EL PASO COUNTY STORMWATER MANAGEMENT PLAN CHECKLIST

PPR2235

These 4 items are not shown on the GEC Plans

HORZ. SCALE: 1"=120'	DRAWN: PV
VERT. SCALE: N/A	DESIGNED: JPS
SURVEYED: ALESSI	CHECKED: JPS
CREATED: 12/06/23	LAST MODIFIED: 04/11/24
PROJECT NO: 112301	MODIFIED BY: PV
SHEET:	<b>C1.1</b>

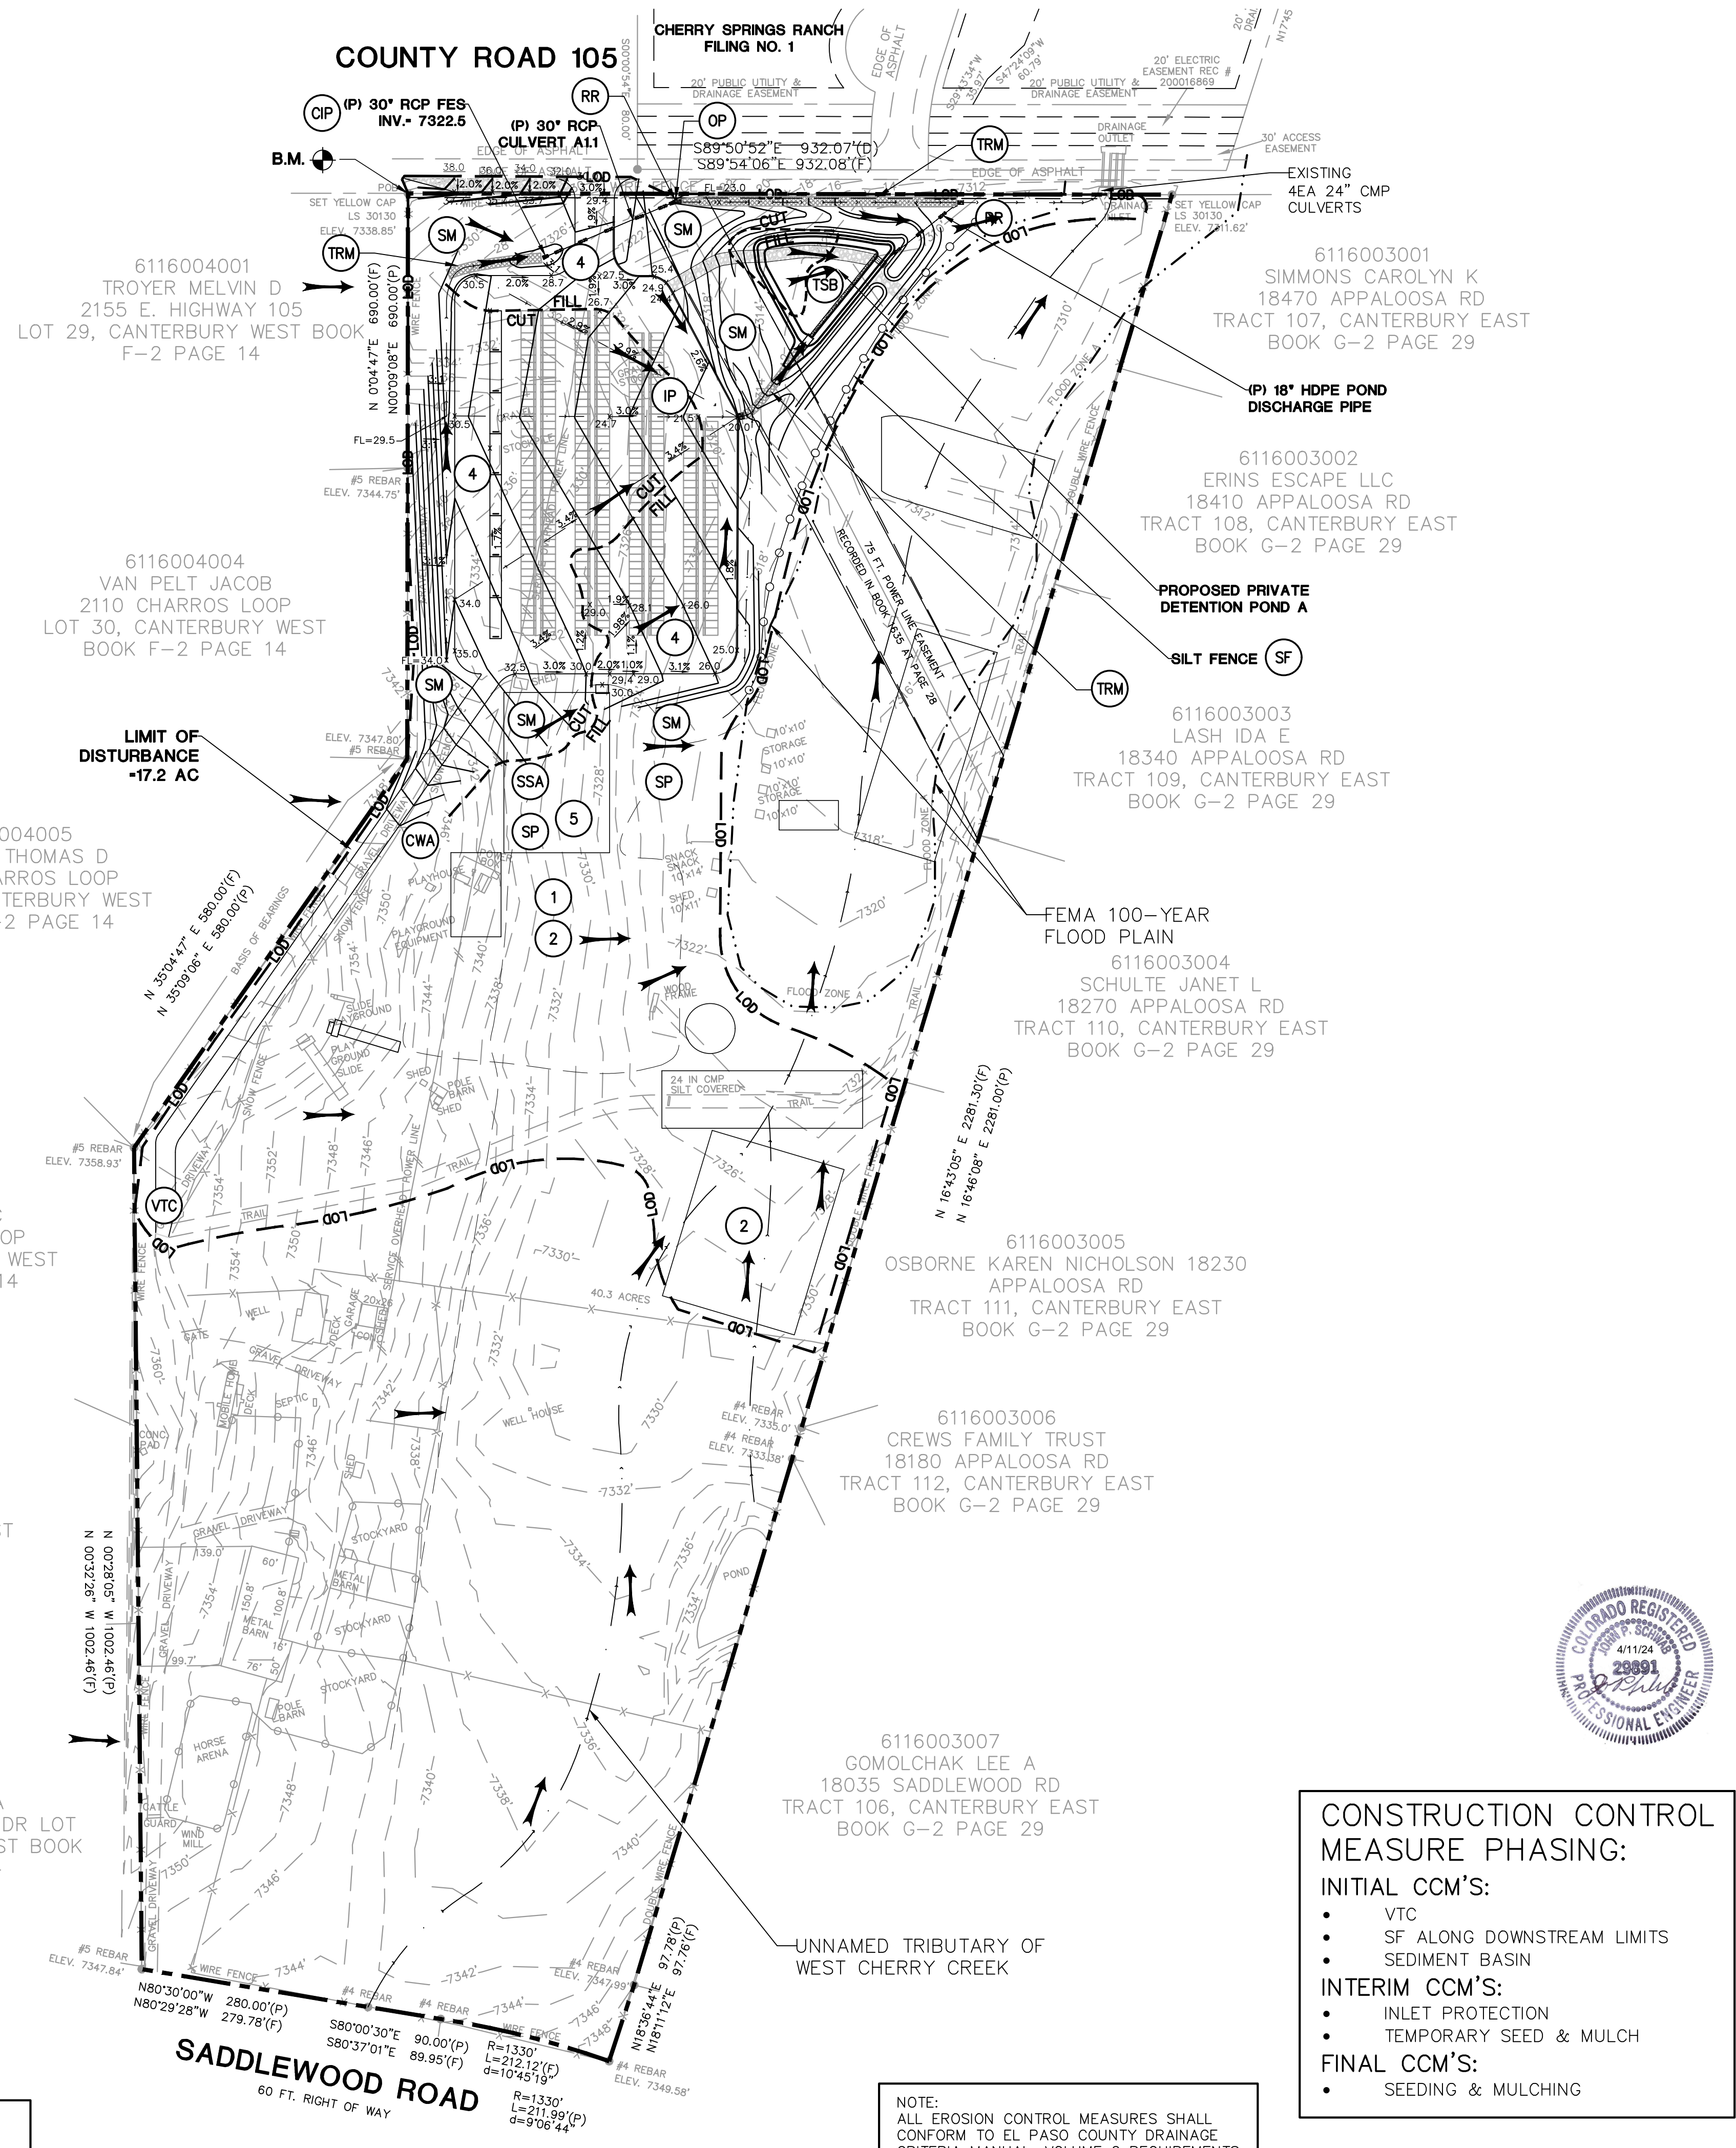
Applicant	EPC
17	SWMP Map to include:		
17a	construction site boundaries		N
17b	flow arrows to depict stormwater flow directions		N
17c	all areas of disturbance		N
17d	areas of cut and fill		Y
17e	areas used for storage of building materials, soils (stockpiles) or wastes		Y
17f	location of any dedicated asphalt / concrete batch plants		Y
17g	location of all structural control measures		N
17h	location of all non-structural control measures		Y
17i	springs, streams, wetlands and other surface waters, including areas that require maintenance of pre-existing vegetation within 50 feet of a receiving water		Y
18	Narrative description of all structural control measures to be used. Modifications to EPC standard control measures must meet or exceed County-approved details		Y
19	Description of all non-structural control measures to be used including seeding, mulching, protection of existing vegetation, site watering, sod placement, etc.		Y
